Letter No. B2/22713/2004.

Sub: CMDA - Area Plans Unit - Planning Permission
Proposed construction of stilt parking floor +
4 Floors Residential building with 21 dwelling
units at S.No.378/28, Durga Nagar Main Road,
Thiruneermalai Village, Chennai - Development
Charge and other charges - Requested - Regarding.

**STATEMENT**

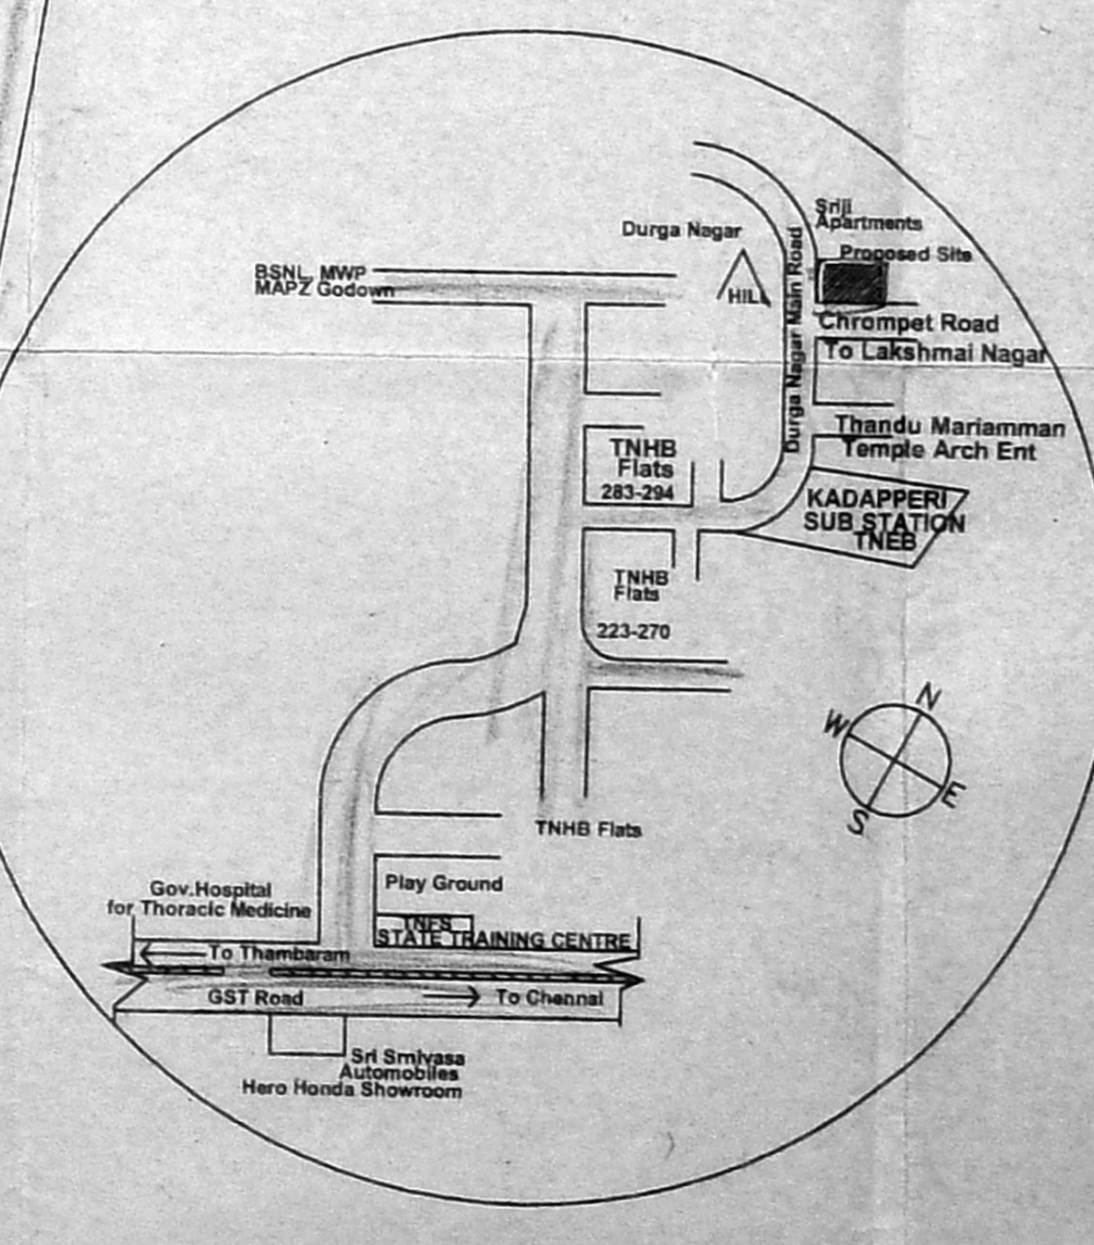
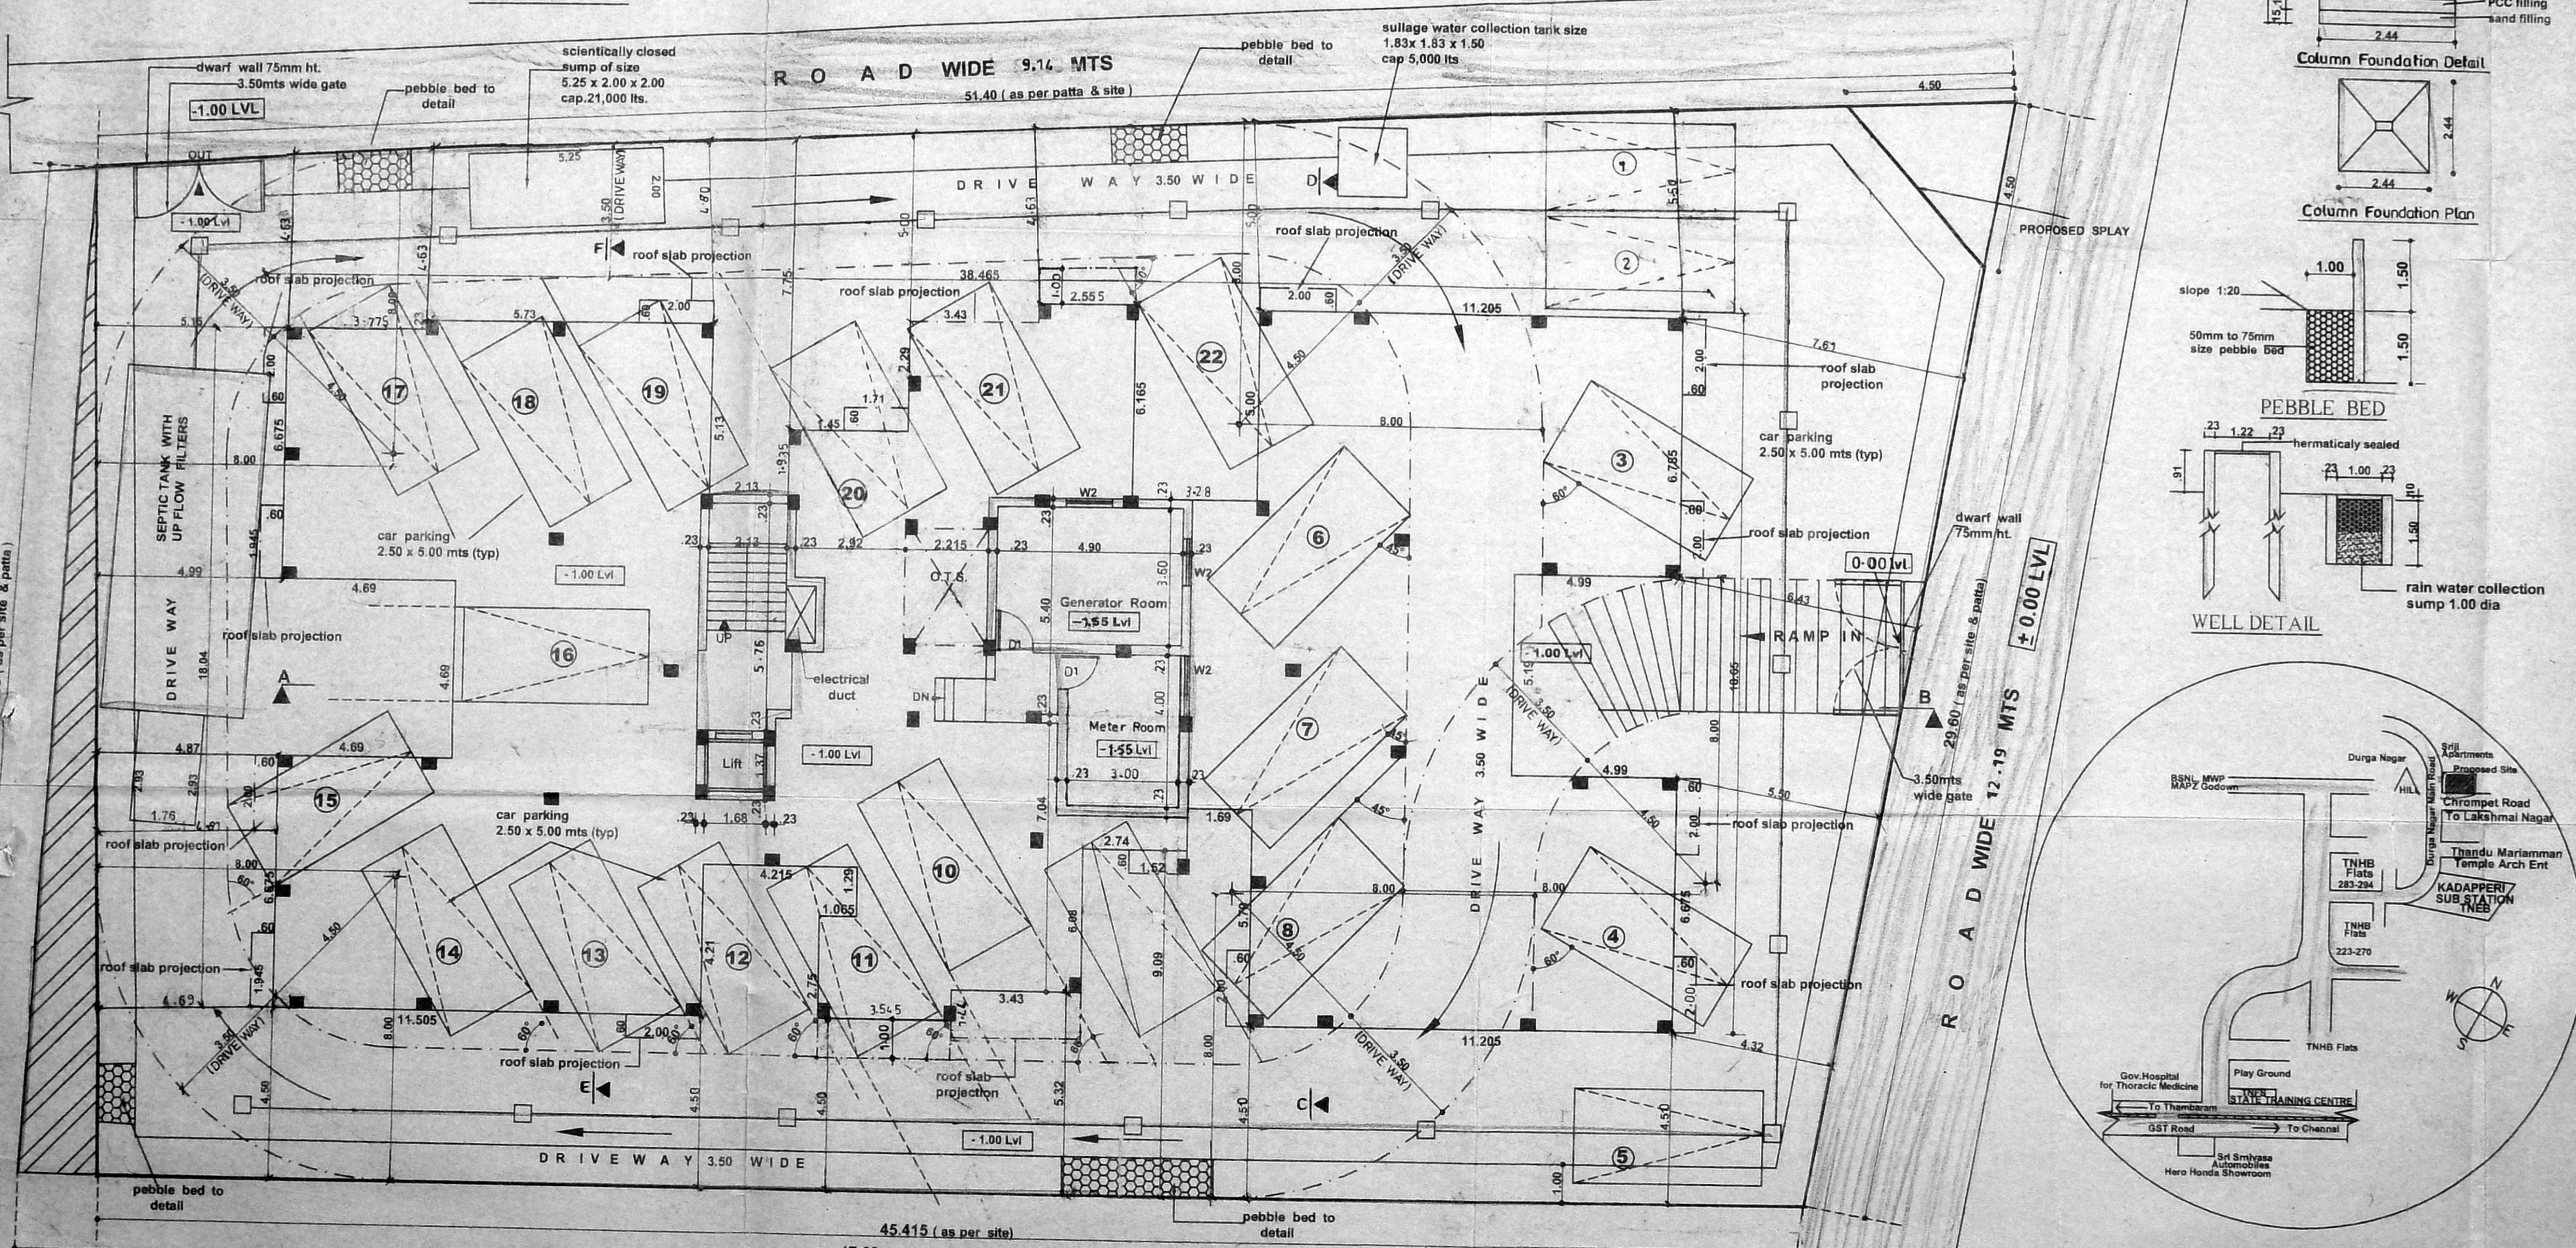
- 5) You are also requested to furnish 5 sets of revised plan rectifying the following defects:
 - 1) Area statement requires correction.
- 6) You are also requested to furnish septic tank with upflow filter design calculation and its detailed drawing from an approved consultant of Chennai Metropolitan Water Supply and Sewerage Board.
